51-E-14  
59 Exeter St.  
USM Law Clinic  
USM

250 Holm Ave.  
Portland, Maine 04102  
(207) 772-2522  
May 6, 2003

Re: USM Law Clinic  
51-E-14  
R-5 Zone

59 Exeter Street  
Portland, Maine

PROPOSED SITE PLAN

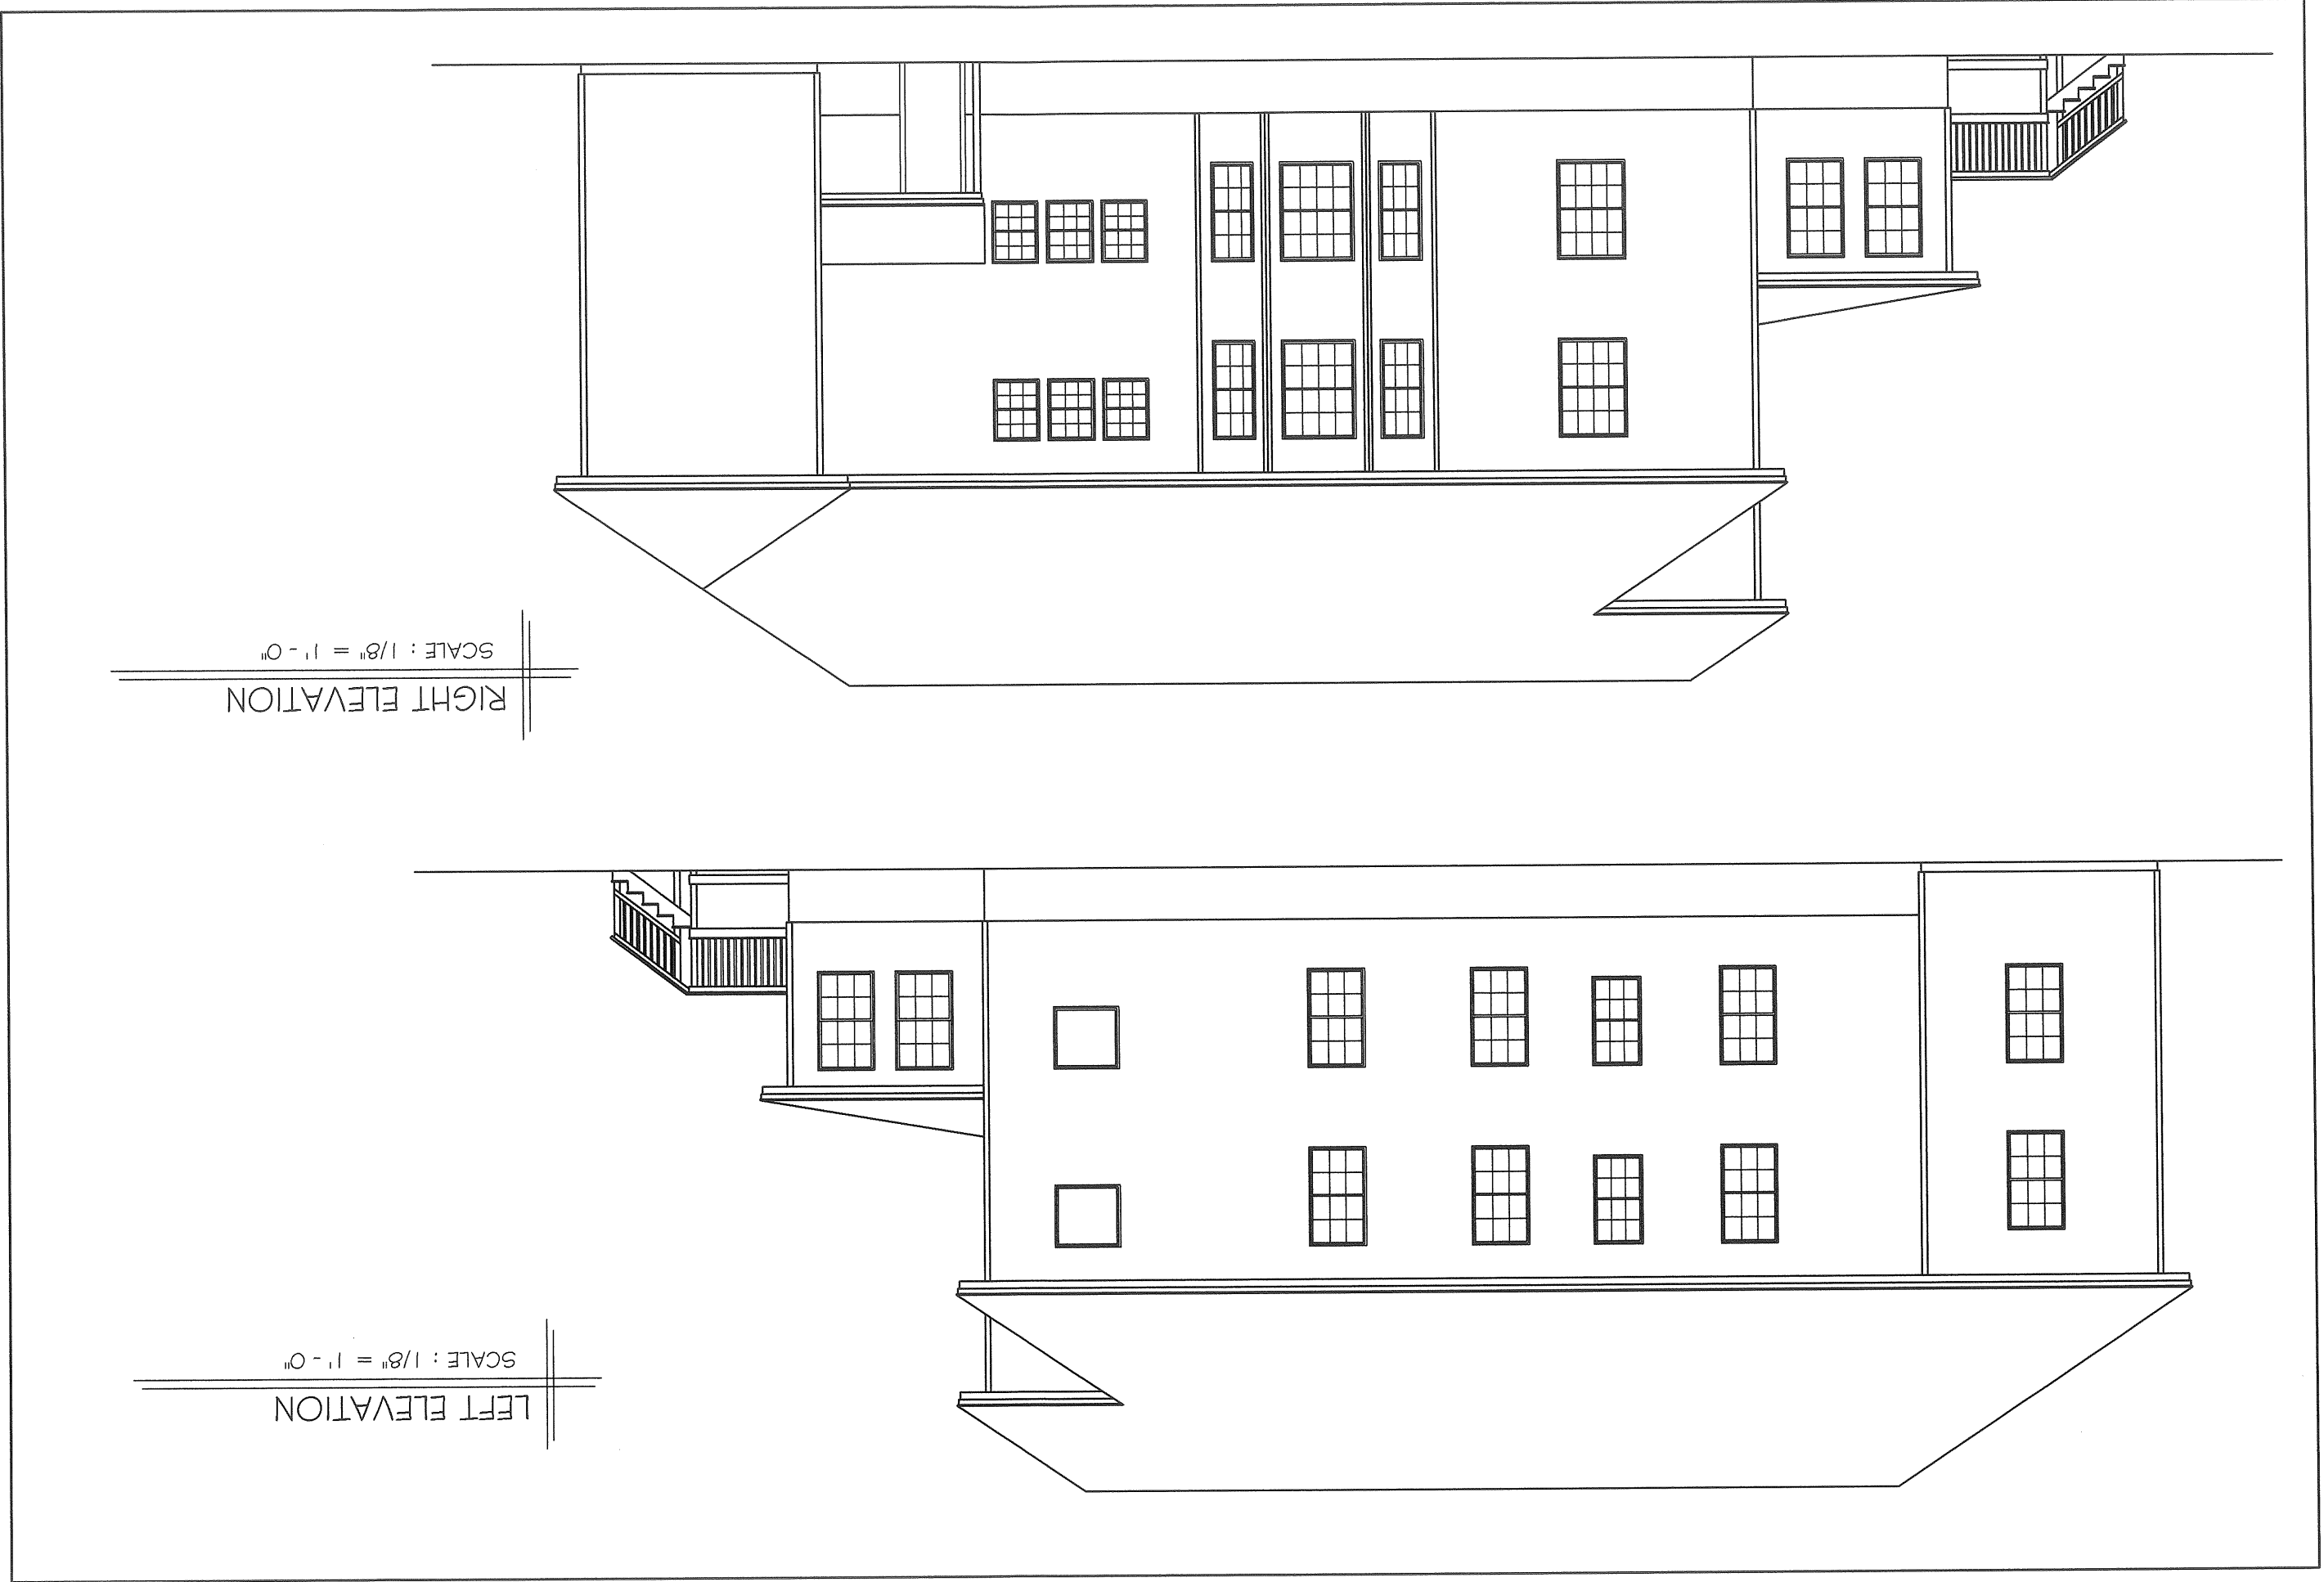
First a concern with comment. This is the second or third plan for the expansion of a building that I have reviewed in the last week or week and a half that did not have a plot or site plan attached. Whenever I have tried to build a project, not only did I need a site plan, but I was also required to have a full survey by a registered land surveyor. When reviewing the projects that I am referring to it was impossible to tell if setbacks, as required by the zoning ordinances of the city, were being adhered to. Therefore I question the setbacks in this case. The front yard must be twenty feet (20') or the average of the two lots on either side. The side yards (this building from the appearance of the pictures submitted, is a 2 1/2 story structure) are to be fourteen feet (14') each; though one may be reduced to as little as eight feet if the other is increased correspondingly to twenty feet. I do not believe that the rear yard will be a problem in this instance.

FRONT ELEVATION
SCALE : 1/8" = 1' - 0"

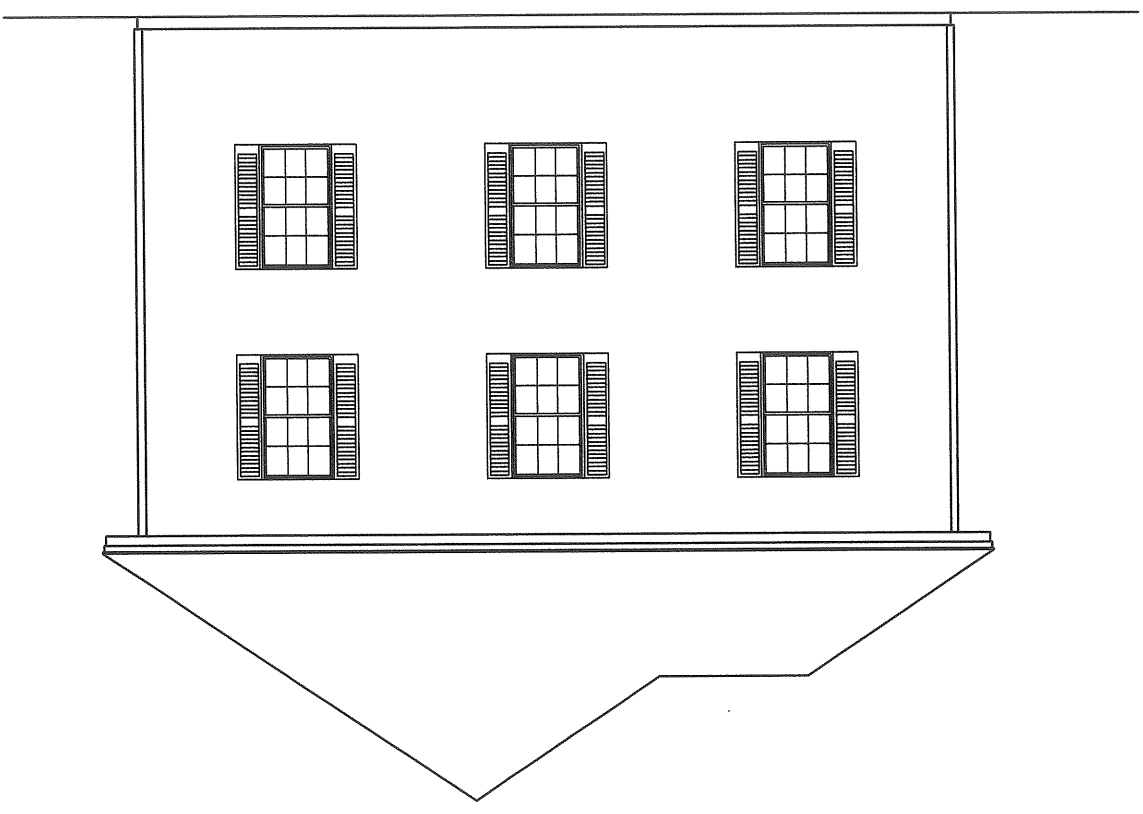
My second concern is that the addition proposed to the front of the building will not be in keeping with the rest of the neighborhood. The new front appearance will not look like any other building on the street, per the photographs as submitted by the applicant.

I have no objection to the addition proposed at the rear of the building. I would suggest that rather than adding to the front of the building that the rear be expanded to accommodate the uses proposed for the front and if need be the existing interior be modified slightly to accommodate all requirements for needed space.
